SSD 7733

**Penrith Resource Recovery Facility (SSD 7733)
Request for Response to Submissions**

Department's Comments

01 PROPOSED SITE PLAN
SCALE 1:500

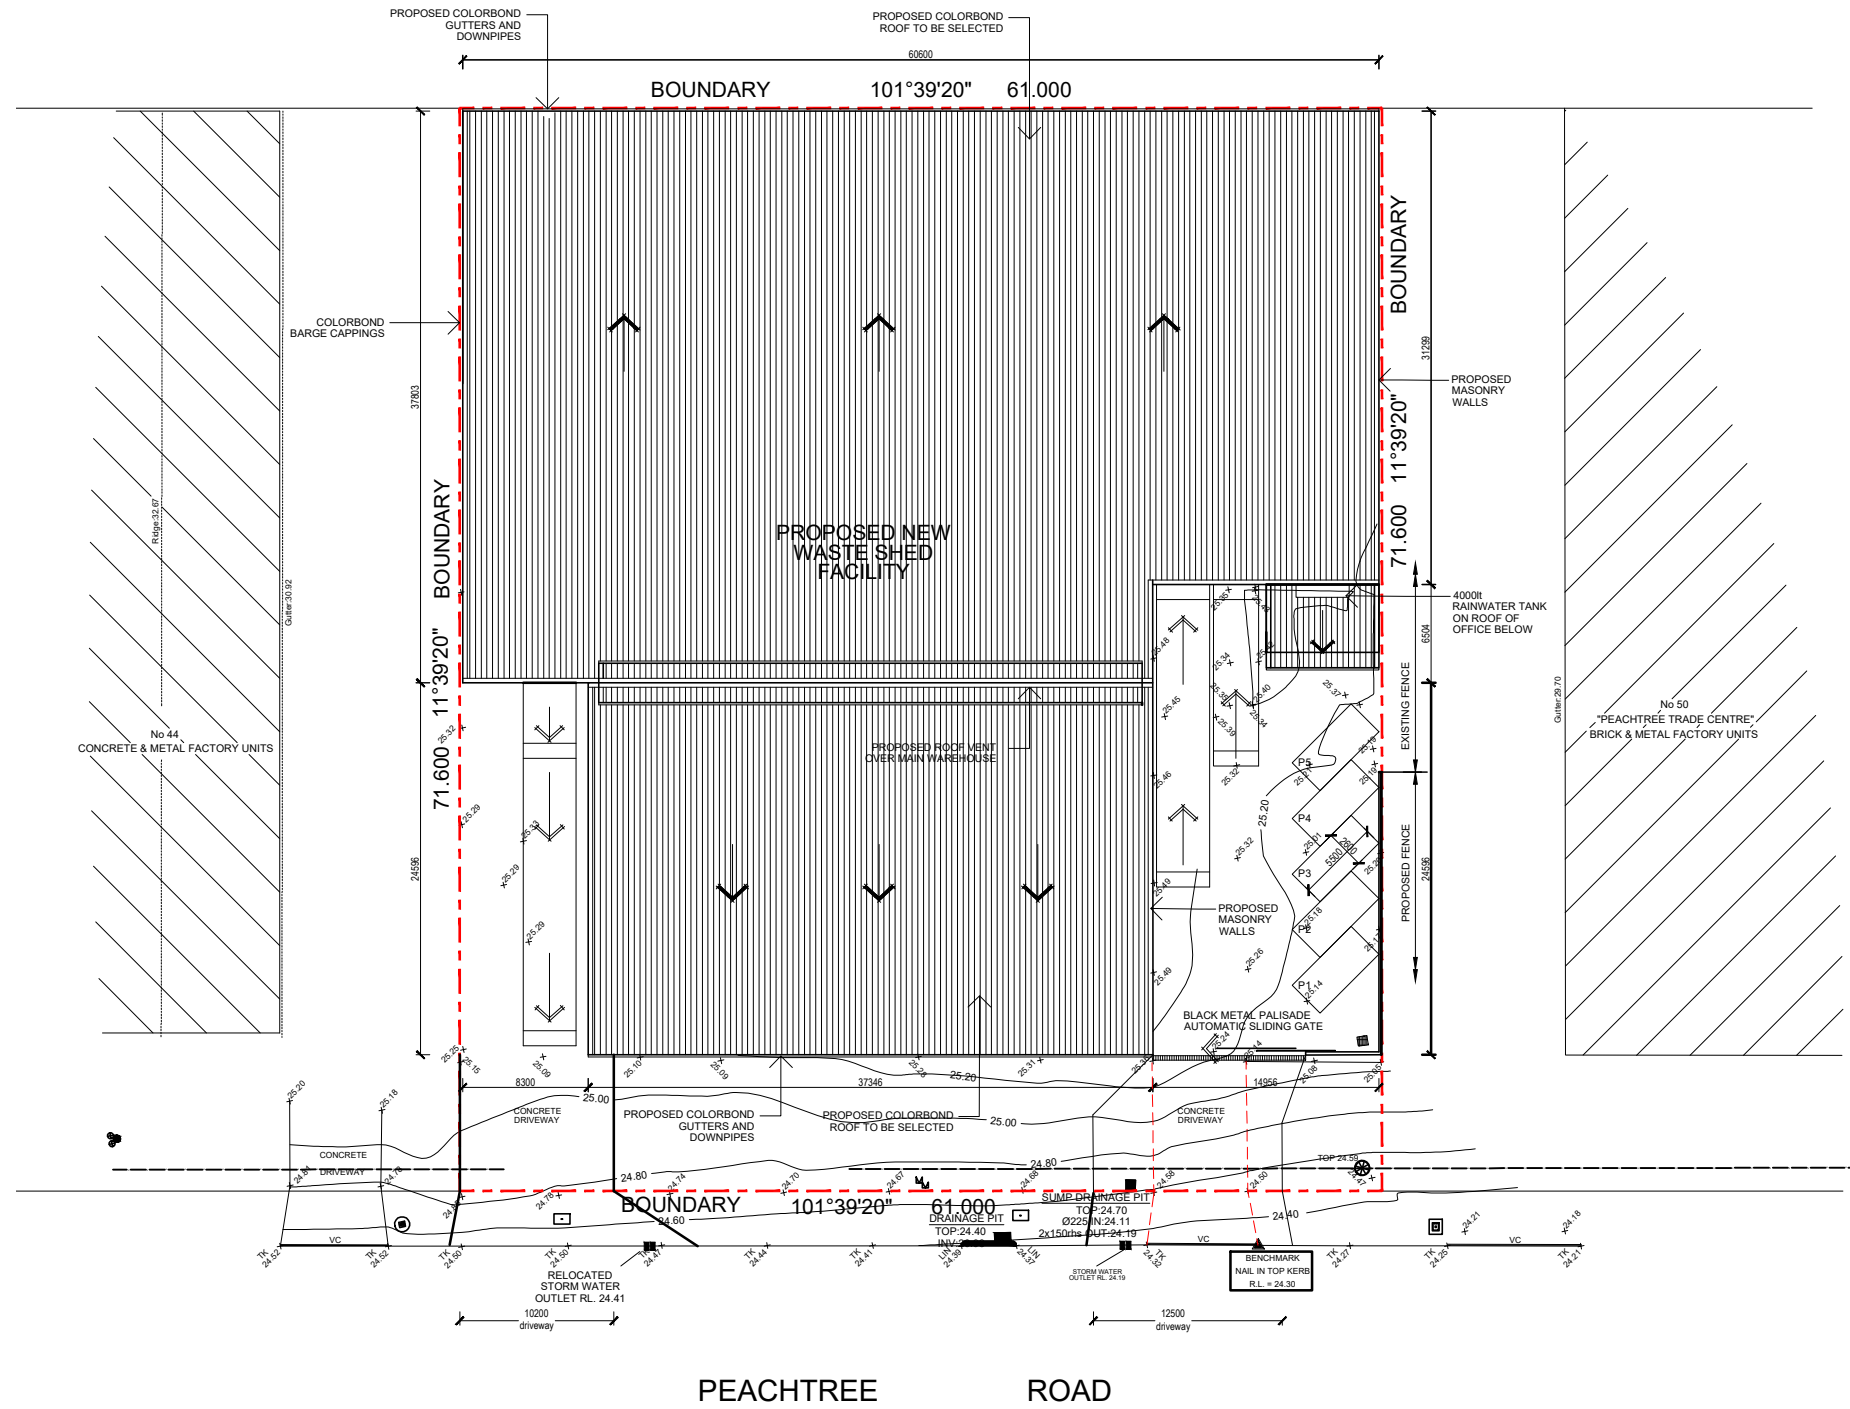
- light vehicle movements throughout the site, including consideration of heavy vehicles; and
 - the siting of "P10" (as shown on the site plan) appears to be within a highly-trafficked area of the site and located within proximity to materials storage bays. Further details are required identifying interactions between a vehicle parking in "P10" and foot traffic, other vehicles using the area, site infrastructure and materials stockpiles.

29. The site plan provided indicates that the proposed new driveway at the south-western corner of the site is to be constructed to the boundary. You are required to provide the following:

- the distance between the proposed driveway and the existing driveway to the west;
 - address safety of vehicles and pedestrians using these driveways;

- address the existing trees located immediately to the west of the proposed driveway (on the adjacent site) and demonstrate they will have no impact on safety and lines of sight;

- the width of the proposed driveway at its widest point; and
 - identify the rectangular box sited within the proposed new driveway as shown on the site plan and provide relevant details regarding the impact of the proposed driveway on this box.

- the EIS states that car parking spaces provided are minimum “2.7m wide by 5.4m long” which is inconsistent with the dimensions of the car parking spaces shown on the site plan and relevant Australian Standards.

01 SOUTH ELEVATION
SCALE 1:250

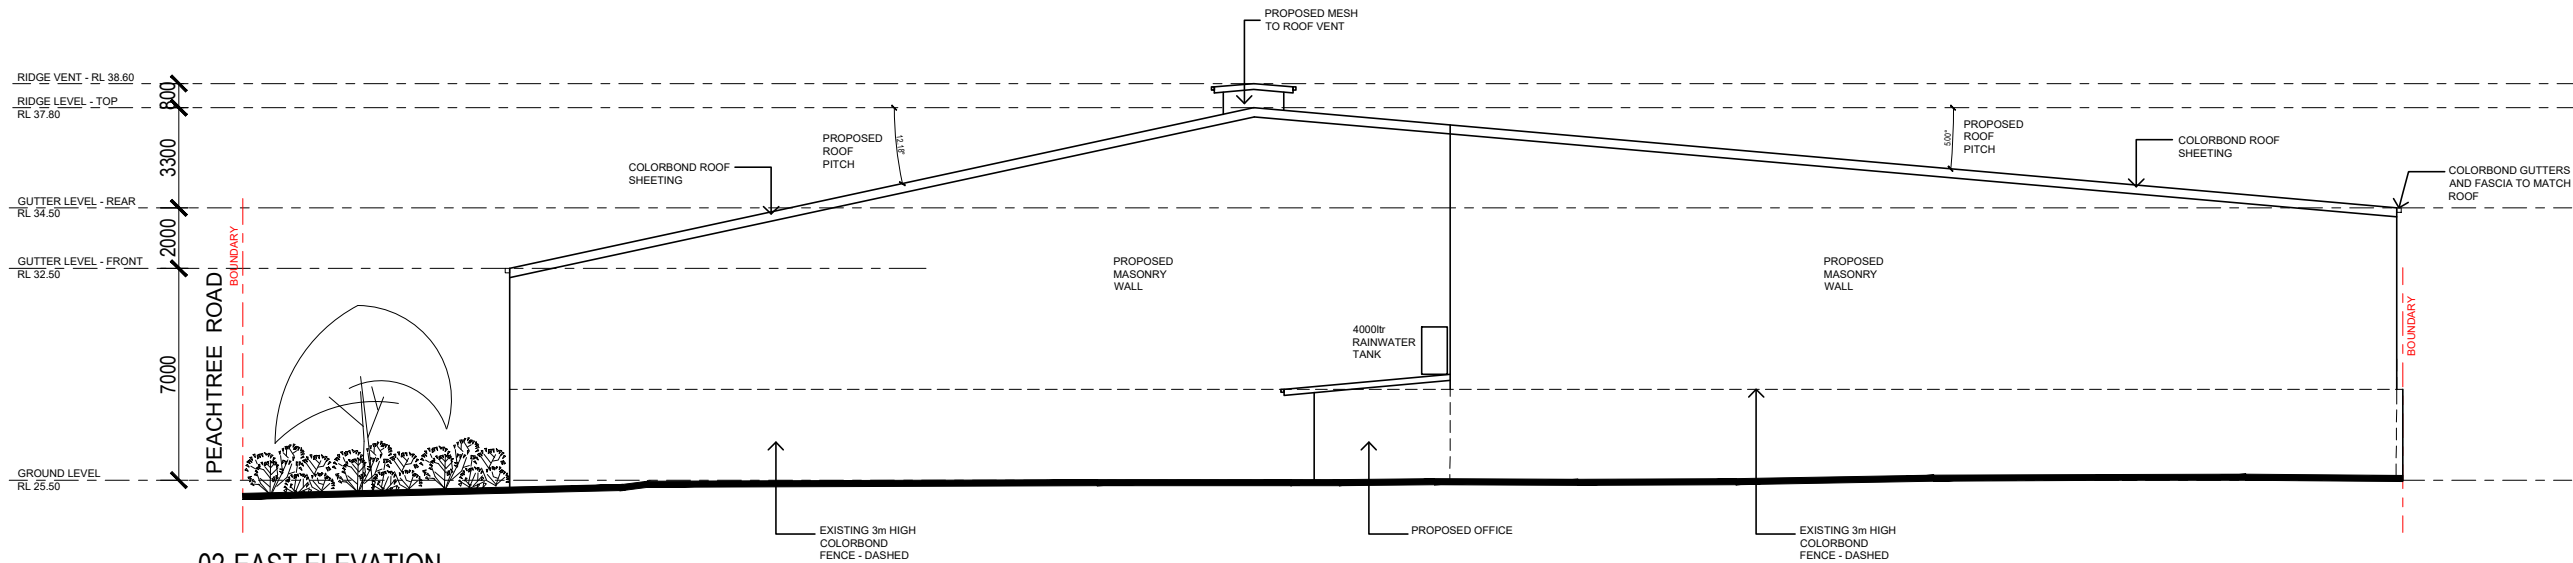
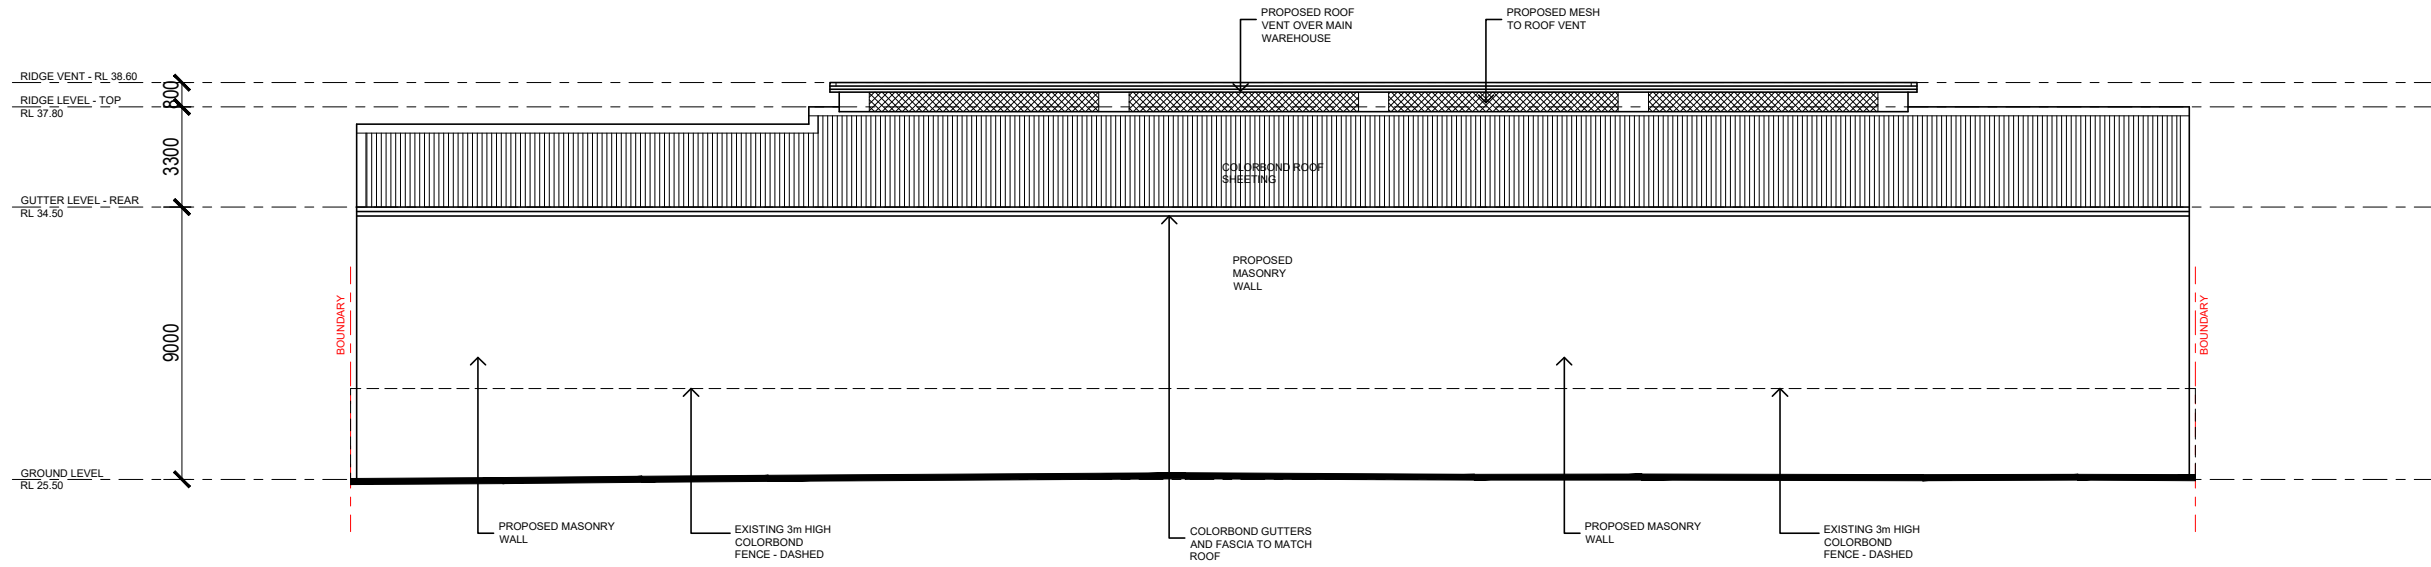
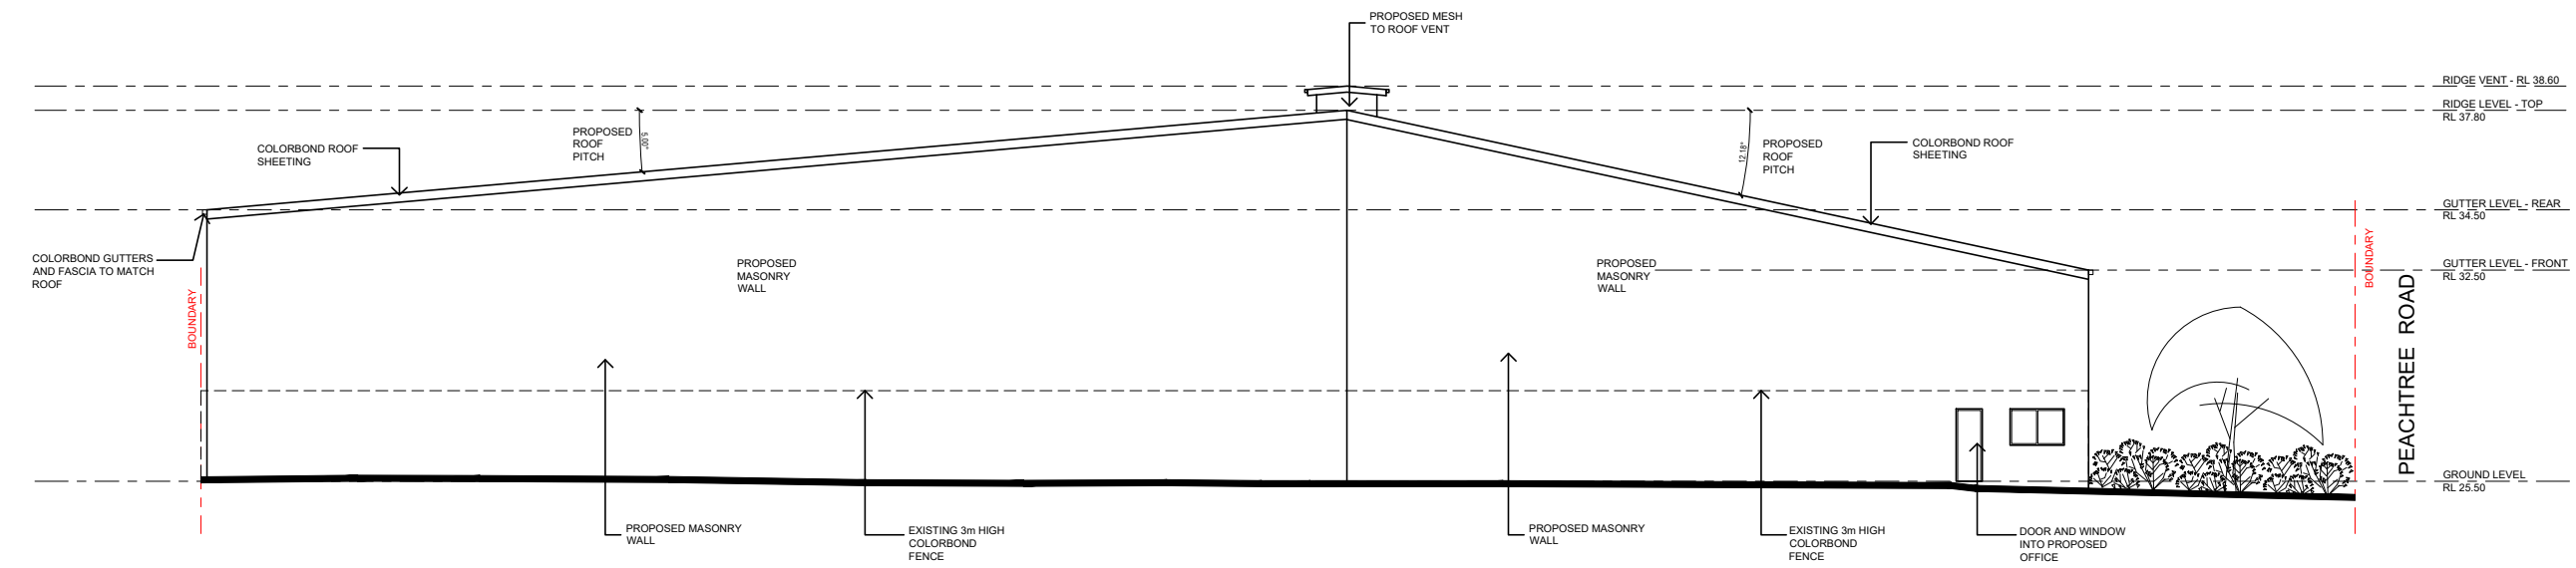
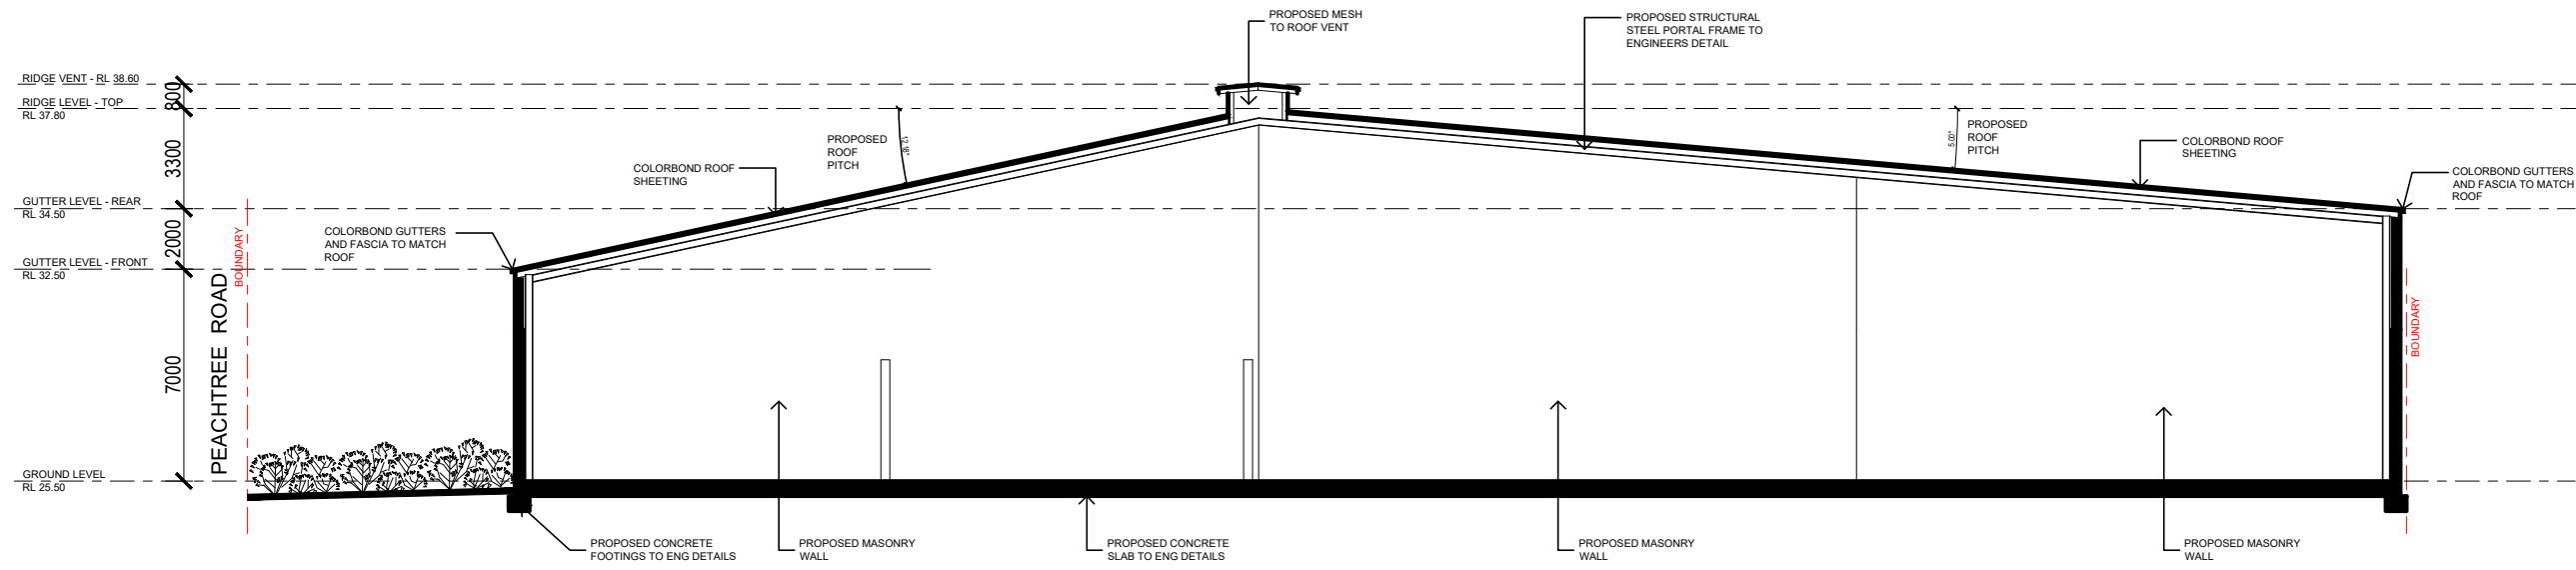
43. Submit amended plans addressing the following:
 - the shed elevations identify “existing metal shed to be demolished” however all other plans identify a metal awning to be demolished in this location;

- an elevation plan removing the boundary fence;
 - the relationship between the north point and the orientation of the existing floor plan (labelled “01 Shed Floor Plan, Drawing A201, Revision A) and the shed mezzanine plan (labelled “01 Shed Mezzanine Plan, Drawing A202, Revision A) appear to be inconsistent with the other plans and drawings provided; and
